**KIRKLEES METROPOLITAN COUNCIL  
INVESTMENT & REGENERATION SERVICE**

**DELEGATED DECISION FOR DISCHARGE OF CONDITION A.4 -  
NOTIFICATION OF A PROPOSED ENLARGEMENT TO DWELLINGHOUSE**

<b>Reference no.</b>	<b>2023/HH/91204/W</b>
<b>Site Address</b>	<b>Hawcote Lodge, Haw Cote, Holme Lane, Slaithwaite, Huddersfield, HD7 5XD</b>
<b>Description</b>	<b>The proposal is for erection of single storey rear extension. The extension projects 4.5m beyond the rear wall of the original dwellinghouse. The maximum height of the extension is 2.60m, the height of the eaves of the extension is 2.4m</b>
<b>Recommending Officer</b>	<b>Luke Walstow</b>

2023-91204

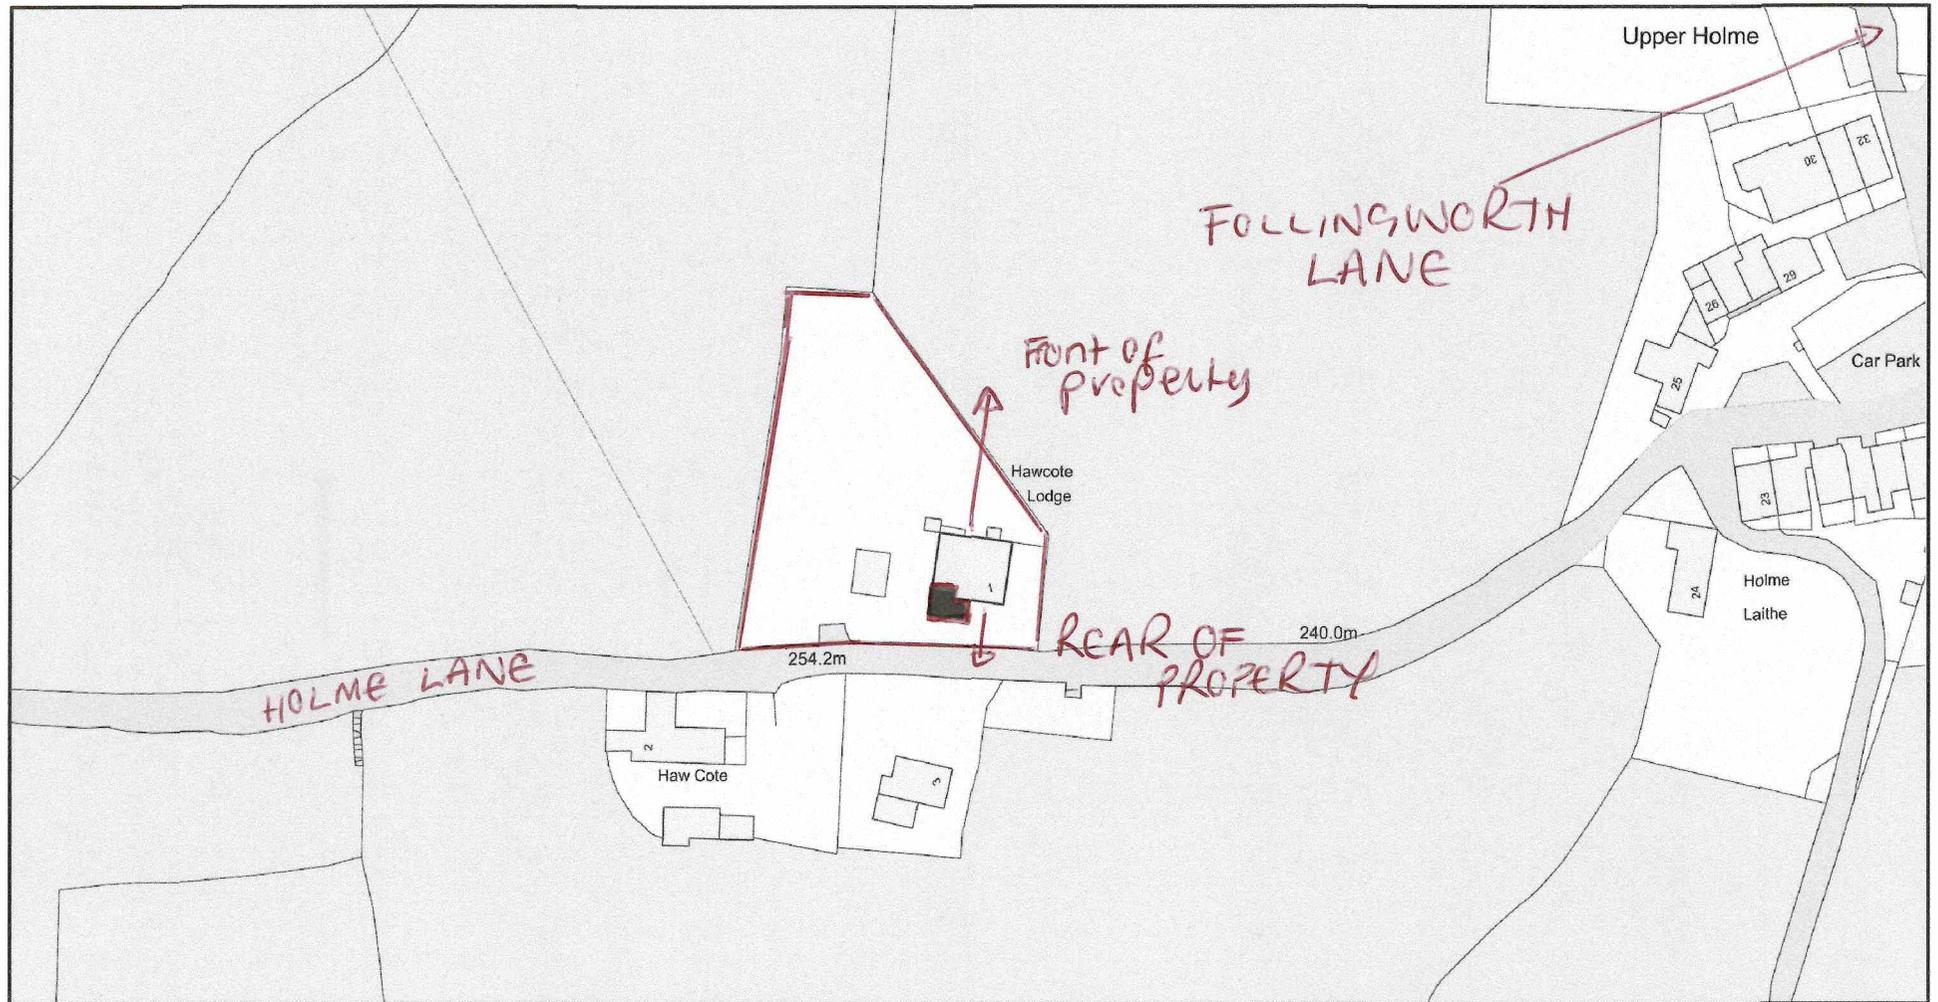
However, the applicant's location plan annotates the north elevation to be the front of the property although there is no supporting evidence to demonstrate this was the principal elevation of the original dwellinghouse. The Council's historic maps indicate the footprint of the building is unchanged from 1922 to the present day although previous planning permission reference 98/93485 suggest the original property was enlarged with a two storey extension. Photographs held on planning permission reference 2017/90525 assist in how the property has evolved over the years and indicate a single storey element of the building existed on the west elevation. There is no contrary evidence to suggest this was not the layout of the original dwellinghouse and as such it can be seen the south elevation consisted of a two storey gable with a single storey gable to the south of the property. Two window openings appear to have existed at ground floor with one on the first floor. Whilst this elevation faces the highway serving the property there are no features or entrances to suggest this was, as a matter of fact and degree, what could be considered a principal elevation. The photographs also indicate the original south elevation only included one small ground floor window with two first floor windows largely obscured by the roof slope of the single storey part. The north elevation is largely devoid of any meaningful design features other than the chimney stack on the gable wall.

The east elevation of the property is in contrast well presented with a neat double fronted appearance with symmetrical window proportions which can be seen from approaches to the property on Holme Lane. The two chimney stacks on each gable wall act as bookends to give the south elevation an appearance as the main elevation with architectural features which would normally to considered to constitute the front of the house. While this elevation is orientated away from the highway it can still be clearly seen from the approaches on Holme Lane

and as such is considered likely to have been the principal elevation of the original dwellinghouse contrary to the applicant's suggestion. This in turn makes the south elevation the rear of the original property.

Under these circumstances and without evidence to suggest otherwise it appears the proposed extension does wrap around part of the rear elevation and along the side albeit the rear projection is only 3.8 metres and as such may not require prior approval. Notwithstanding the above this is not a formal determination on this point as paragraph A.4, Part 1, Class A of Schedule 2 of the Town and Country (General Permitted Development) (England) Order 2015 (as amended) only provides for the LPA to refuse a prior approval application if in the opinion of the LPA the proposed development does not comply with the relevant conditions and limitations in Class A. If the applicant wishes the Local Planning Authority to take a formal determination on the lawfulness of the proposed development they may wish to seek a certificate of lawfulness under the provisions of Section 192 of the Town and Country Planning Act 1990.
